Recommendation Report for Planning Permission for Works or Extension to a Dwelling

REF NO: PO/1/20/HH

LOCATION: 9 Arundel Road
Poling
BN18 9PW

PROPOSAL: Retention of car port to side elevation & raised roof to existing garage.

Proposed Roof Plan

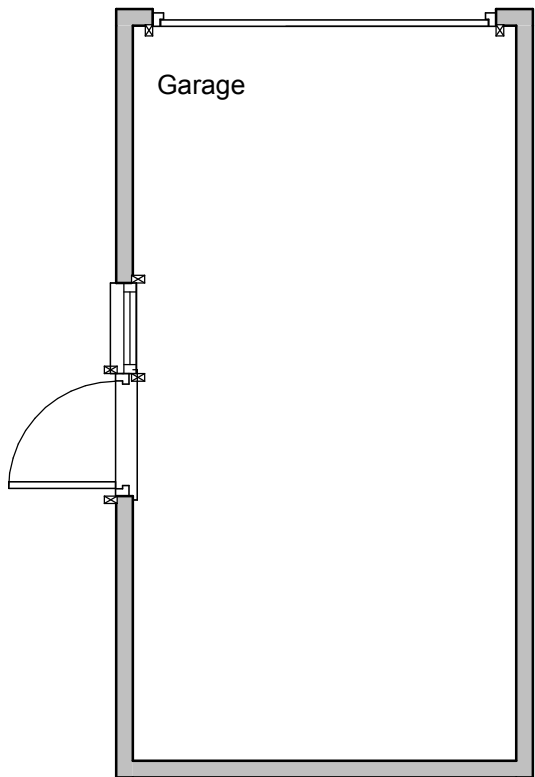
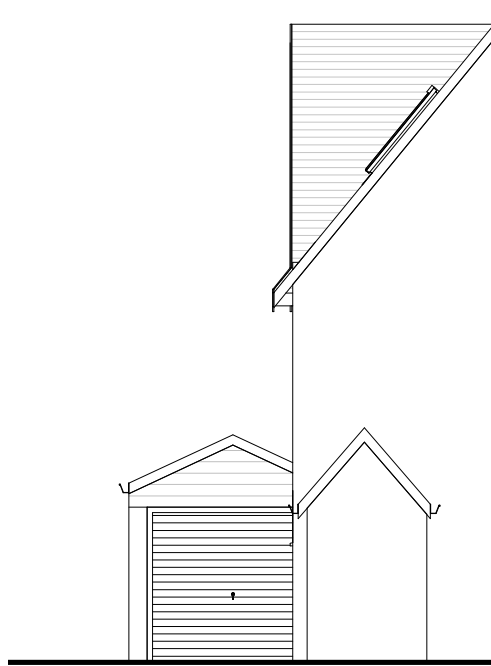
The proposed change of roof design of the garage is not considered to result in a significantly harmful impact upon the character of the host dwelling, or its wider locality. The proposal does not result in any significant increase in the height of the proposal, in that it largely just alters the design of the roof from centrally pitched, to a lean-to design.

The proposed change of the roof of the garage is not considered to result in any significantly harmful

impact overshadowing or overbearing impact on the occupiers of the neighbouring dwelling to the East. The proposed roof would result in a 0.1m height increase when adjacent to the Eastern boundary of the application site, to a height of 2.5m. The proposed roof slopes to its maximum height away from this boundary.

Proposed Front Elevation North

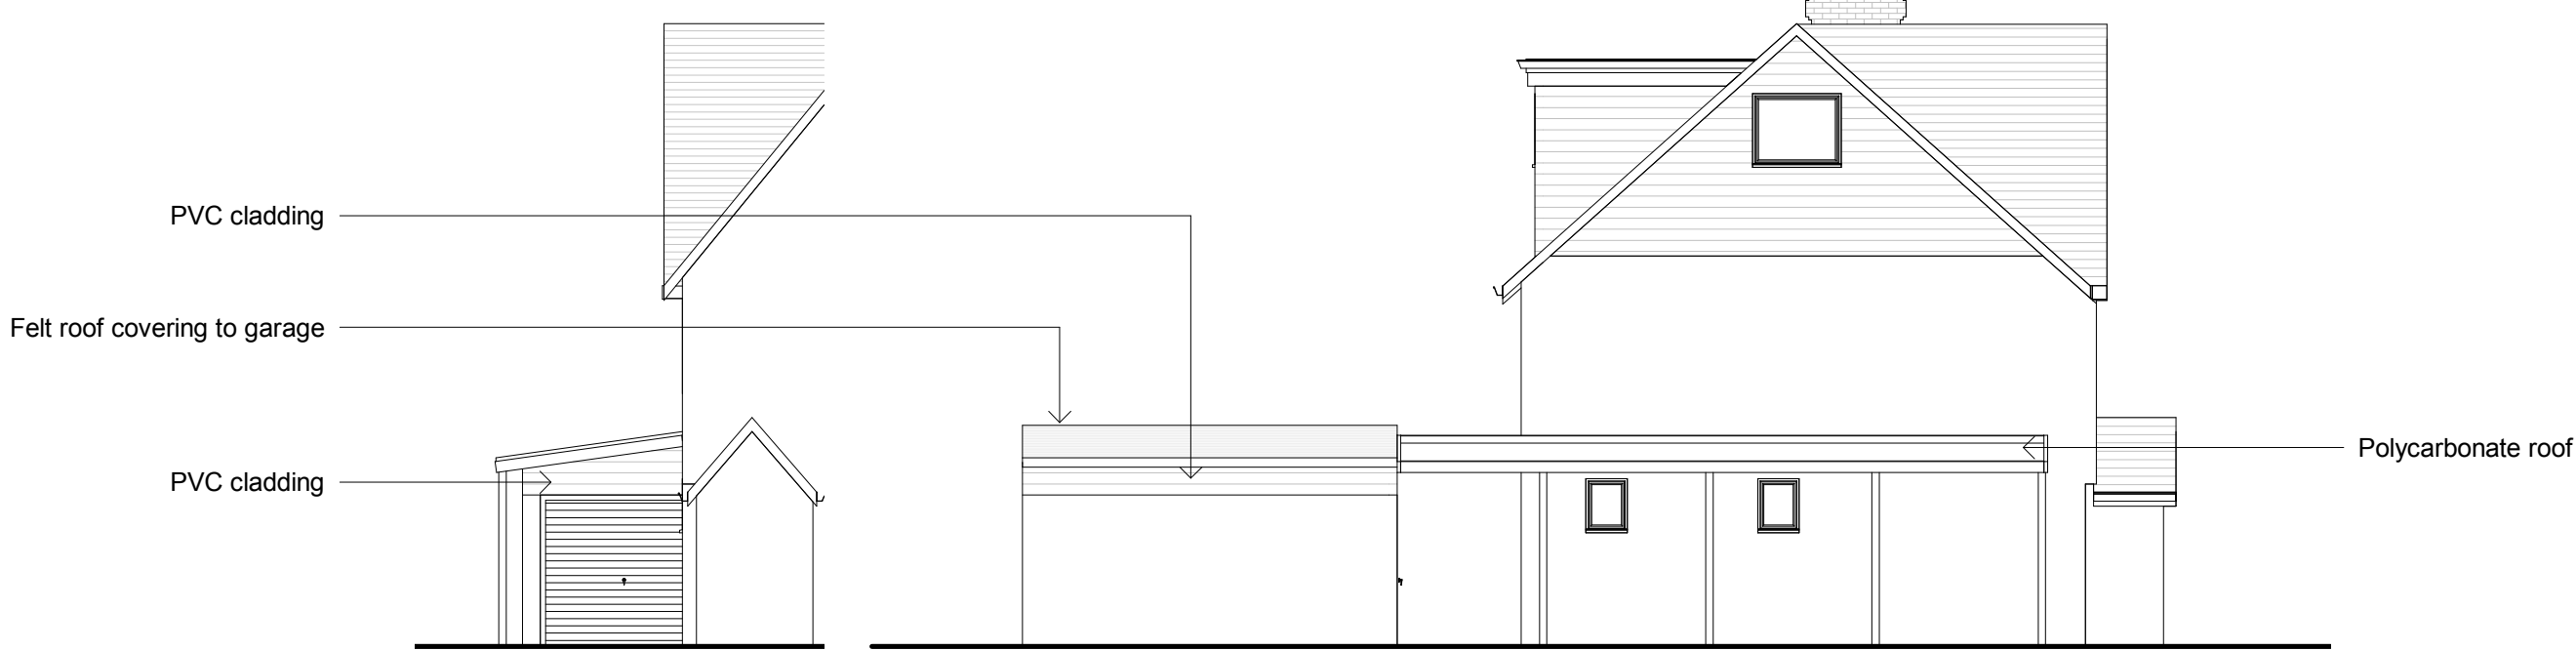
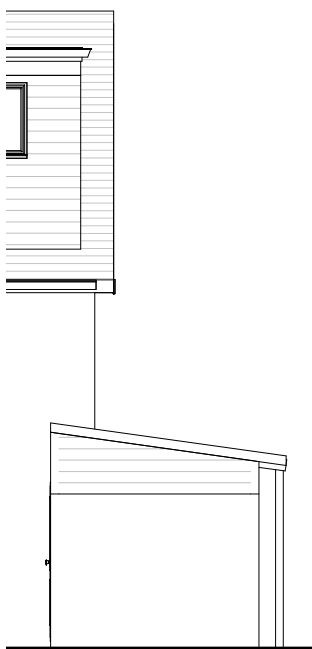
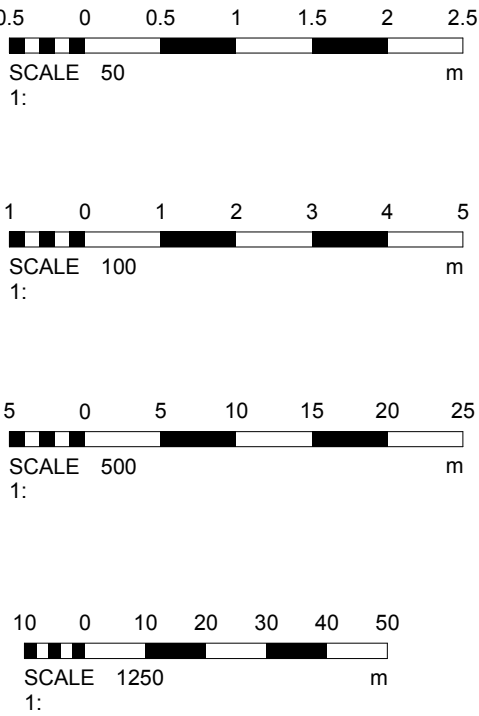
The carport has a maximum height of 2.77m, as a result of this and its light construction, it is considered to appear subservient to the host dwelling. The proposed carport is sited approximately 9.5m from the street scene, is single storey and of a light construction. As a result of these factors, it is considered to have an acceptable impact upon the character of the host dwelling and wider locality. Furthermore as it is open on all four sides the impact on the street scene will be further reduced. The design of the proposal will not jar with the area given the mixed character of the dwellings in the locality and wide range of scales, designs and orientations.
